**CITY OF PORTLAND, MAINE
DEVELOPMENT REVIEW APPLICATION
PLANNING DEPARTMENT PROCESSING FORM
DRC Copy**

161 - 161 Hope Ave , Portland, Maine

RE:
Lot 22
Presumpscot River Place

From: Jay Reynolds [mailto:JAYJR@ci.portland.me.us]
Sent: Wednesday, August 20, 2003 12:03 PM
To: Doug Reynolds
Cc: RWK@ci.portland.me.us; SH@ci.portland.me.us
Subject: PRP III, Lot 22 Review

Drawing Name: Lot 22 Grading and Drainage Plan

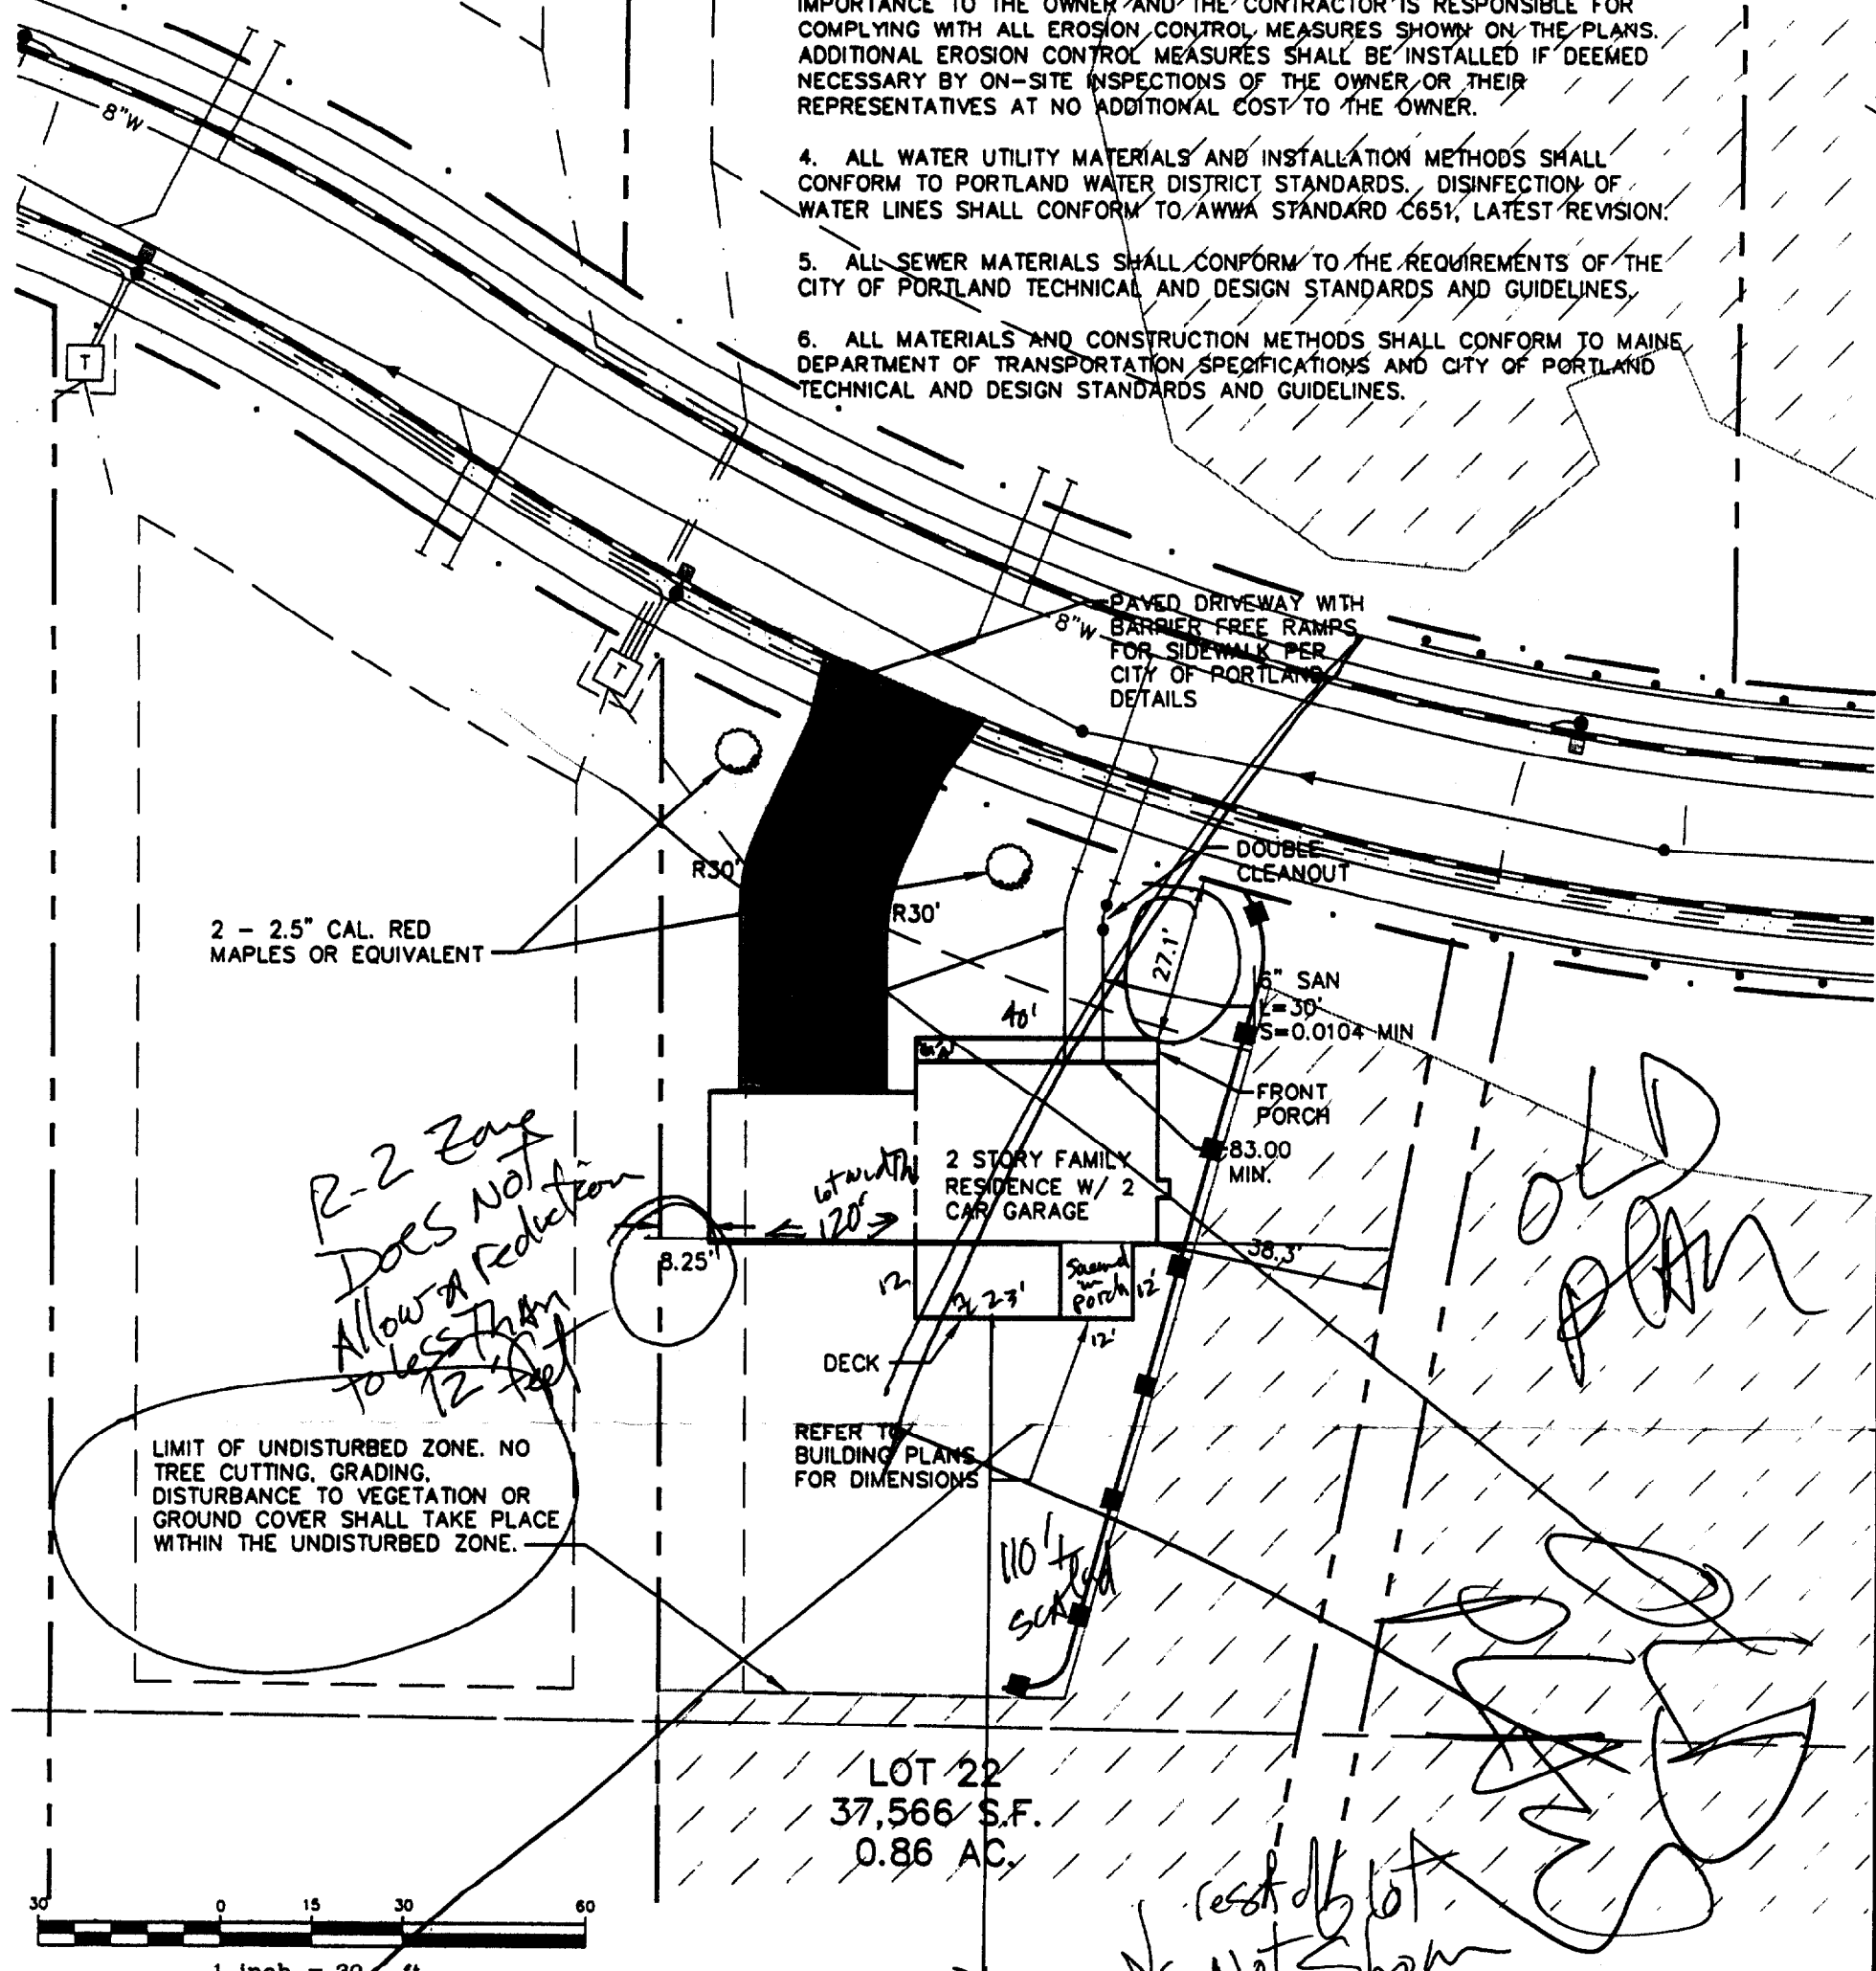
If there are large Trees right at the edge of the zone, construction will damage the root systems of these trees. They would eventually die. Maybe the owner will want them removed due to being so close to the house.

If it's vegetation/scrub, then I guess we'll just see how it gets built out. At a minimum, the plans need to show and protect this area better (silt fence prior to construction?).

More attention is needed with regards to the 'Undisturb Zone'.

The proposed building sets within 3 feet of this zone.

The plan does not show any disturbance, however, the realities of construction tell me that this area will be disturbed, whether it's clearing, grubbing, erosion control installation, foundation pouring, etc. (Also, final grading on Contour 91 goes right to the very edge of the zone).

This undisturb zone is not clearly labelled and defined on your grading plan.

Please hatch/label the zone.

Please label the existing contours.

Please provide additional notes, narrative, or re-design to ensure compliance to the subdivision (undisturb zone).

Added *note* regarding survey of undisturbed zone.

LIMIT OF UNDISTURBED ZONE. NO
TREE CUTTING, GRADING, OR
DISTURBANCE TO VEGETATION OR
GROUND COVER SHALL TAKE PLACE
WITHIN THE UNDISTURBED ZONE.
